# Rezoning Transportation Analysis

Petition Number: 2020-015

Date	Description
02-16-2020	First Review

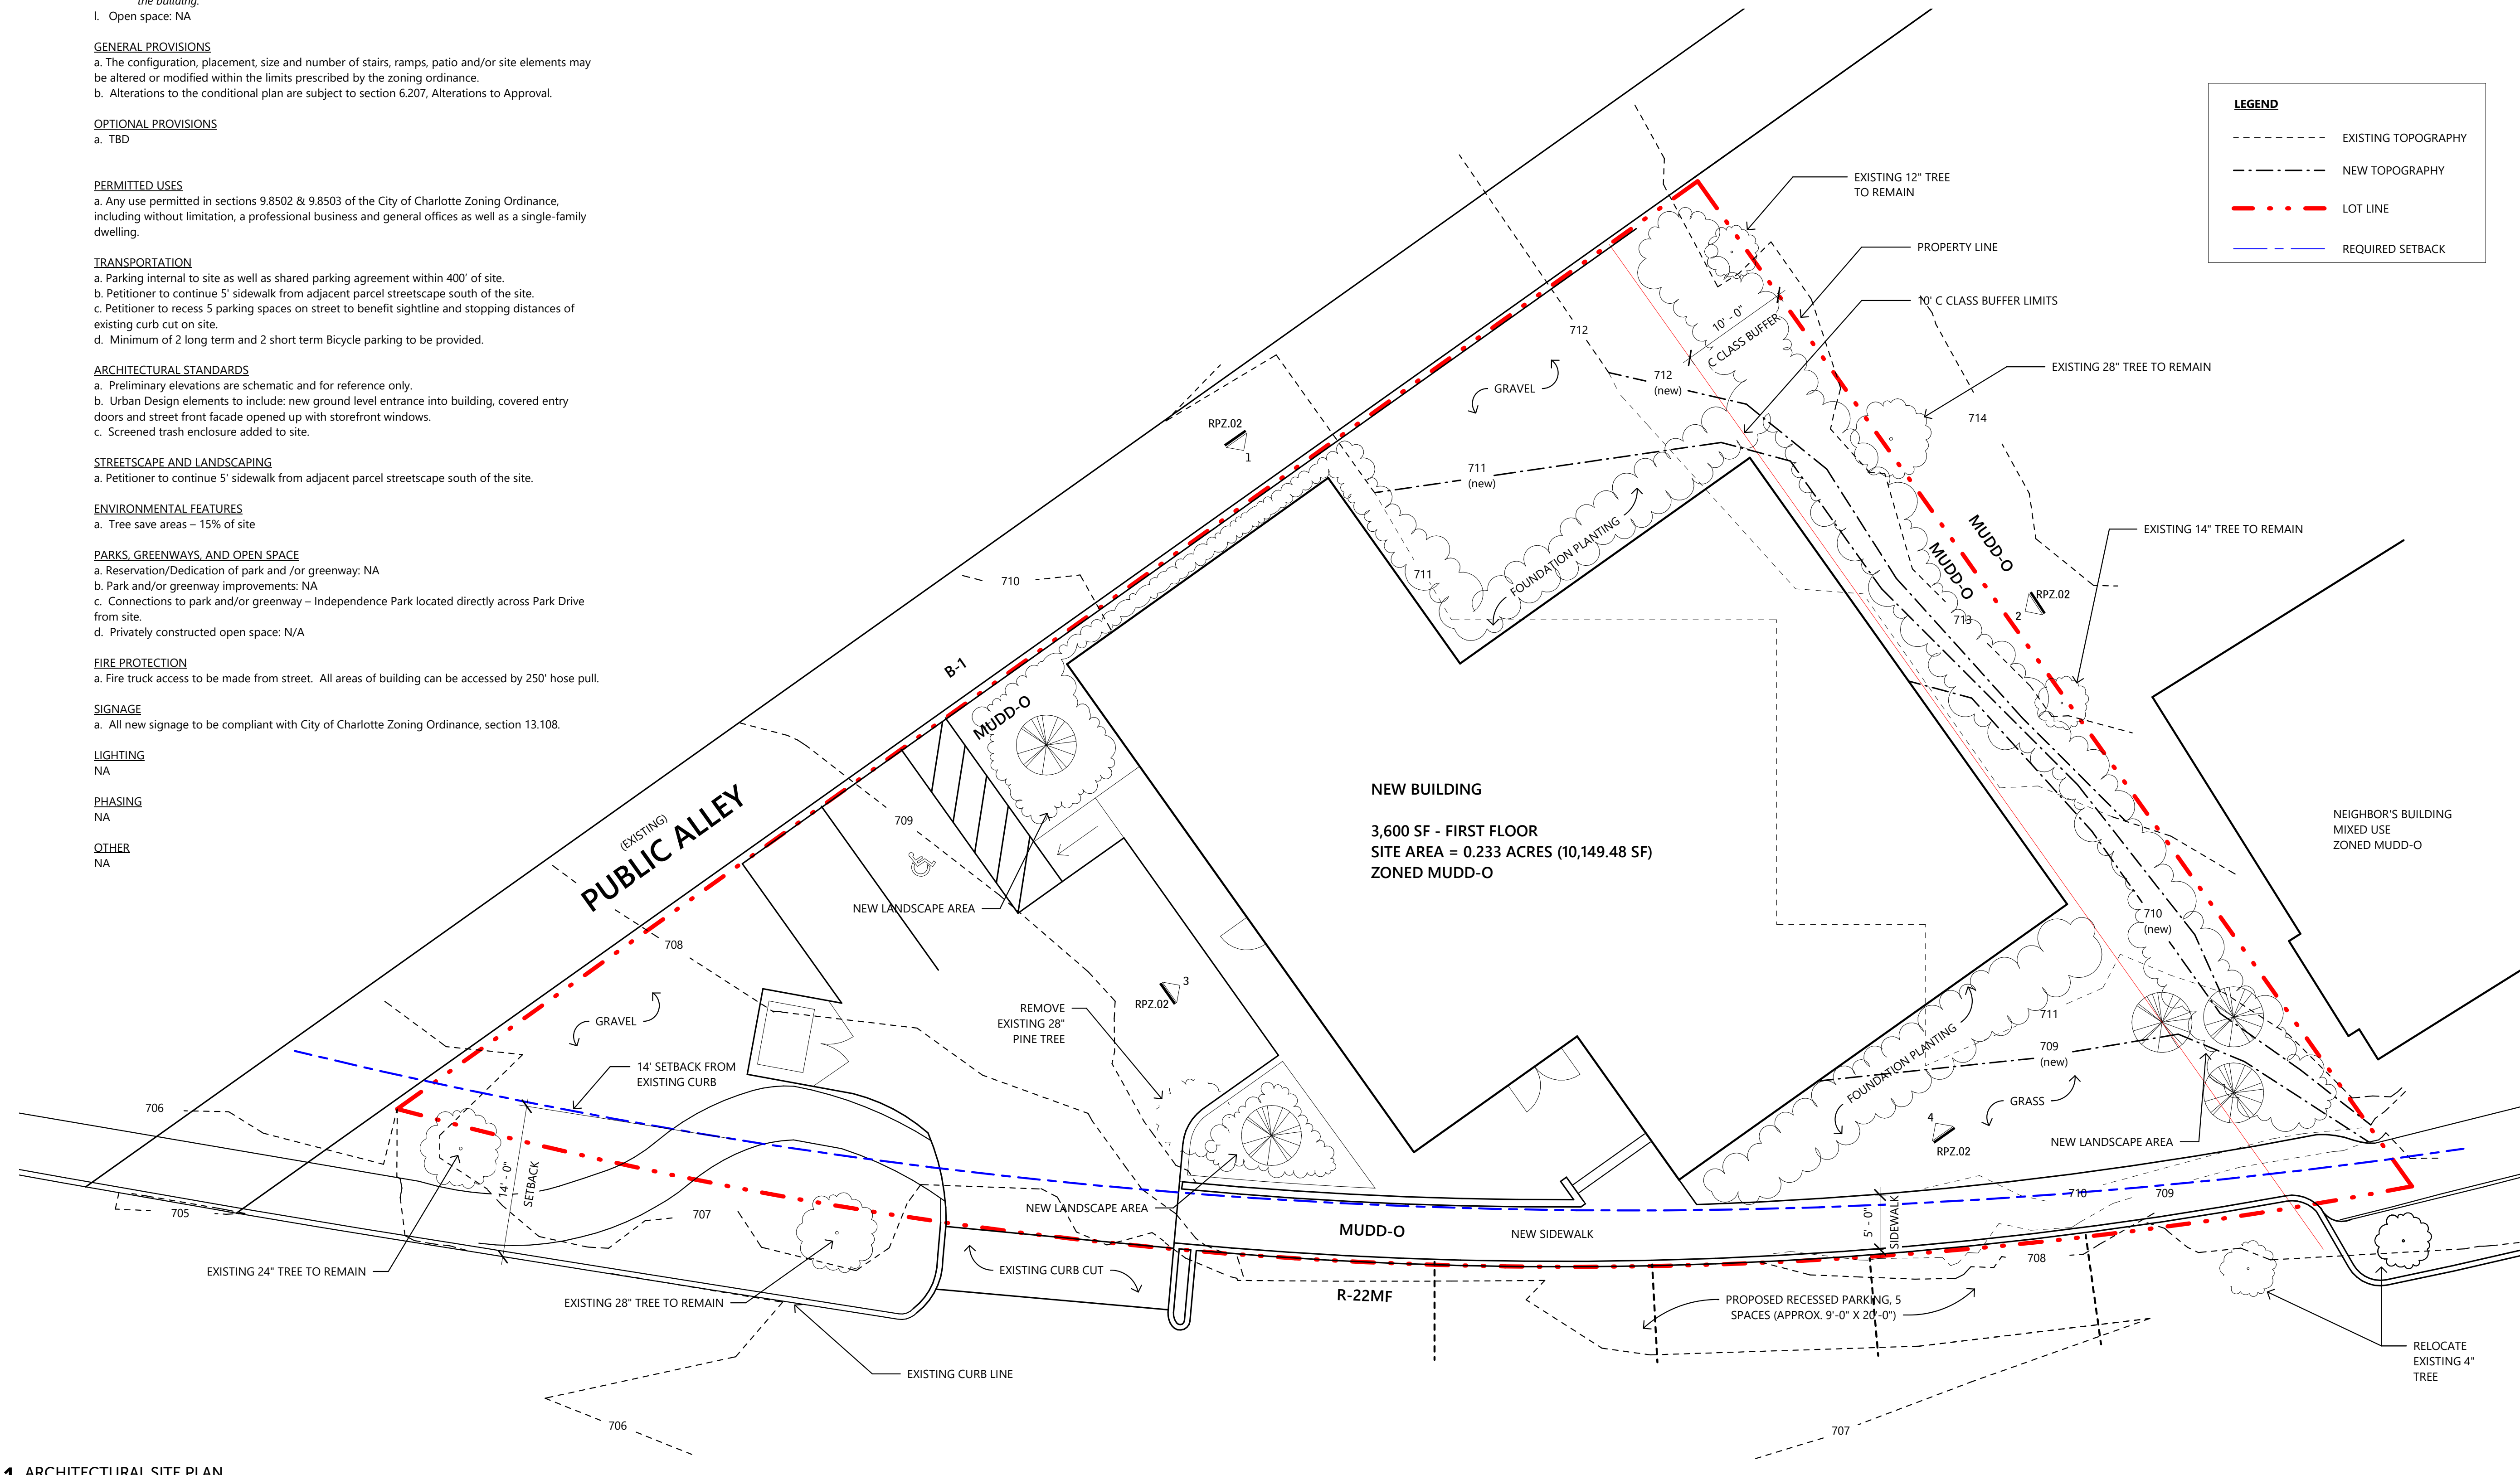
1. **Curbline** The proposed zoning district has a setback measured from back of the existing or proposed future curbline.
  - a. **Park Drive:** The future location of curb and gutter is in its existing location.

The site plan should show the curb and gutter labeled and dimensioned from the centerline for each road.

3. The petitioner should revise the site plan and conditional note(s) to build the recessed parking space to meet CLD standards. CLDS 50.09C
4. The petitioner should revise the site plan and conditional note(s) to remove note B. under Transportation and construct the proposed back of curb sidewalk from 5' to 7' minimum.

5. The petitioner should revise the site plan and conditional note(s) to close the existing curb cut on Park Drive and create a driveway access on the public alley. This will limit potential vehicular conflicts along Park Drive and allow for a better traffic flow. This will also better utilize the public alley for what it was intended for.

6. The petitioner should revise the site plan to add a note specifying dedication and fee simple conveyance of all rights of way to the City before the site's first building certificate of occupancy is issued. CDOT requests right of way set at 2' behind back of sidewalk where feasible.

7. The petitioner should revise the site plan to add a note specifying all transportation improvements will be approved and constructed before the site's first building certificate of occupancy is issued. The petitioner may phase transportation improvements if said improvements and phasing are explicitly described in site plan notes.
